Re: Proposed Water Supply Project for the Eastern and Midlands Region
in the counties of Clare, Limerick, Tipperary, Offaly, Kildare, and Dublin.

Ár dTag | Our Ref.
TII25-134619

Bhur dTag | Your Ref.
PA92.323980

RE: Proposed Water Supply Project for the Eastern and Midlands Region in the counties of Clare, Limerick, Tipperary, Offaly, Kildare, and Dublin. - Uisce Éireann

INDICATIVE CONSTRUCTION WORKING WIDTH - LAUNCH PIT AREA  
 SCALE 1:100

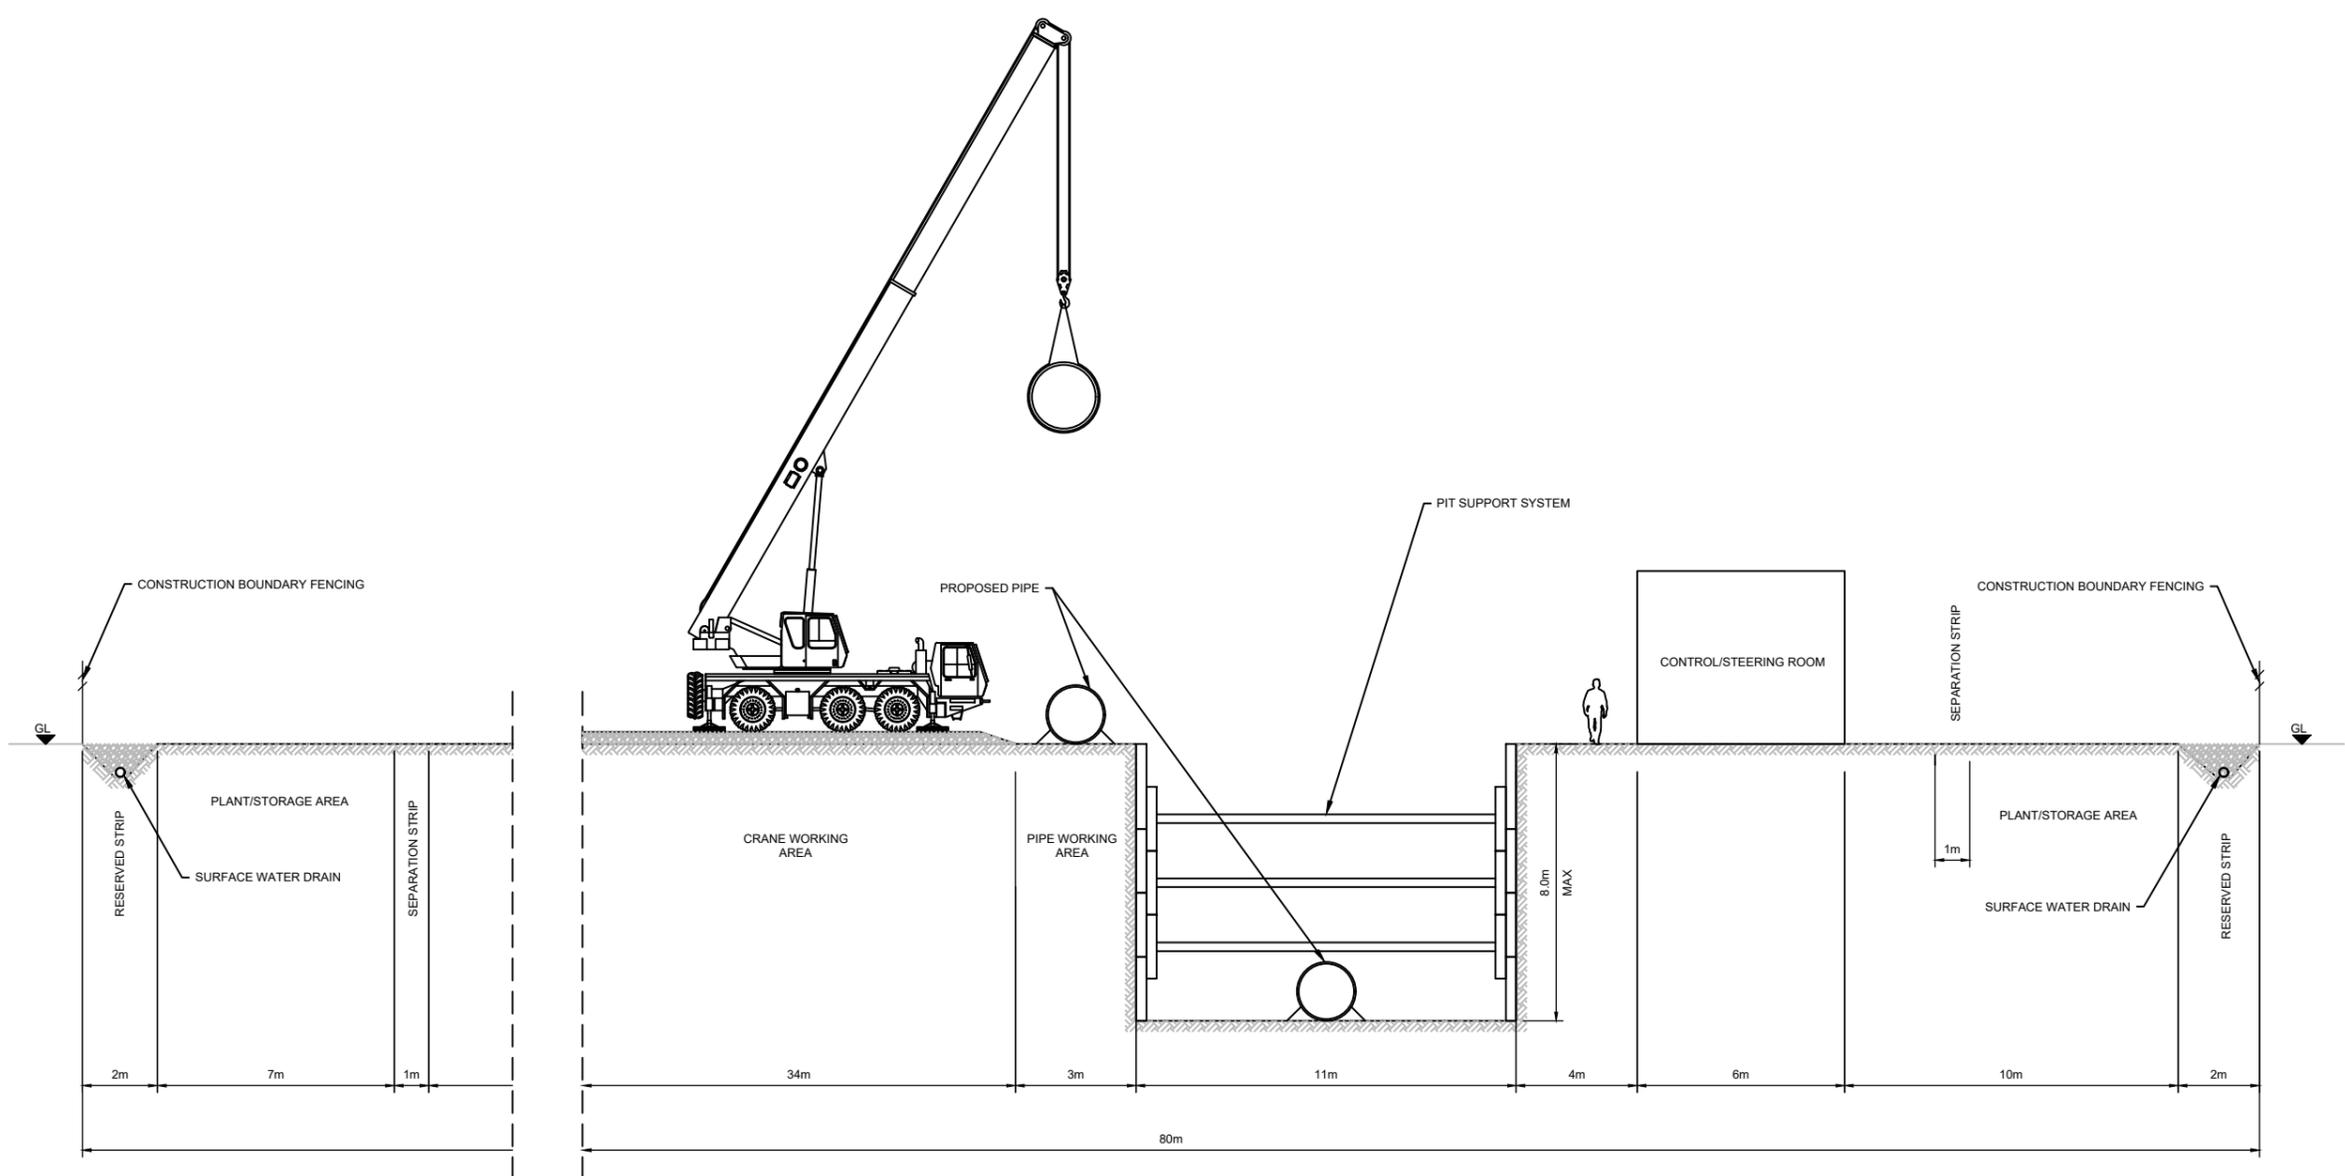
TII identifies 5 no. trenchless crossings of the national roads network are proposed for the pipeline element of the proposal; 2 no. crossings of the M7; and single crossings of the N52, N62 and N80... TII has the following general requirements in respect of any crossings of the network for the avoidance of disturbance of the National Roads Network, TII advises preference trenchless crossings to be designed and constructed such that:

- The launch and reception pits for the crossing are located outside the motorway/dual carriageway boundary,
- The cabling will be installed at such depth so as not to conflict with the drainage for the motorway/dual carriageway,
- Neither the works nor the pipeline crossing will damage or interfere with the motorway/dual carriageway,
- Any maintenance and/or future planned upgrades of the cabling at the crossing location can be carried out without access to the motorway/dual carriageway boundary,
- There are no bolted joints in that part of the crossing within the motorway/dual carriageway fenceline.

The indicated commitment to avoidance of above ground disturbance is welcome. However TII is unable to identify whether this is a qualified and evidenced commitment especially with reference to EIAR *Chapter 18 Material Assets* section 18.4.2 *Construction Phase*, 18.4.2.1 *Risk of Settlement* and *Table 18.21: Predicted Levels of settlement* which indicates "maximum level of settlement" for crossing RDX007 as 11mm and RDX015 as 13mm. TII observes that this reported maximum level of settlement will be "reduced" from that reported and assessed and the "embedded mitigation" is intended to achieve this reduction.

With concern TII must advise the Commission that settlement levels in ranges reported by the applicant far exceed the thresholds set out on *TII Publication (Standard) CC-PAV-04007*). Further, no evidence has been provided to demonstrate the deviation from TII established requirements would be acceptable. In addition, TII also consider that the mitigation measures proposed do not address the established TII requirements for a motorway crossing. Sub-standard proposals which are based on unsubstantiated basis and evidence may create serious significant impacts on the physical integrity of the M7 which would be disruptive to the operation of the critical M7 and costly for the Exchequer to remedy.

TII acknowledges the proposed utilisation of "trenchless" crossing methodology for the M7. However, from the information submitted, TII is unable to identify the exact motorway crossing methodologies to be deployed such that the Authority is confident that no settlement of the M7 occurs during the construction or operation of the proposed development or that potential settlement is to be clearly avoided as part of embedded mitigation.

- (i) Prior to a decision being made, the applicant shall submit appropriate plans and details which shall demonstrate that the proposed crossings of the M7 (crossing refs. RDX0007 and RDX0015) are to be in strict compliance with TII Publications.

- (ii) Prior to commencement of development, an updated Construction Environmental Management Plan (CEMP) shall be prepared which shall include the following commitments in relation to trenchless underground crossings of the national roads network (M7, N52, N62 and N80) as appropriate: -
 - a) a pre-construction survey along the length of the crossing over the extents of the motorway/dual carriageway boundary.

- b) commitment to and methodology for, the preparation and submission of, a post-construction survey along the length of the crossing over the extents of the motorway/dual carriageway boundary.
- c) record of consultation with the Motorway Maintenance and Renewals Contract (MMaRC) Network B Contractors, via TII and the relevant road authority.
- d) record of works specific indemnities, Section 53 consent and arrangements for third party access as arise following consultation with thirdpartyworks@tii.ie; and
- e) details demonstrating compliance of works on, or in the vicinity of the national road with TII Publications, including *TII Publication (Standard) CC-PAV-04007 - Requirements for the Reinstatement of Openings in National Roads*.
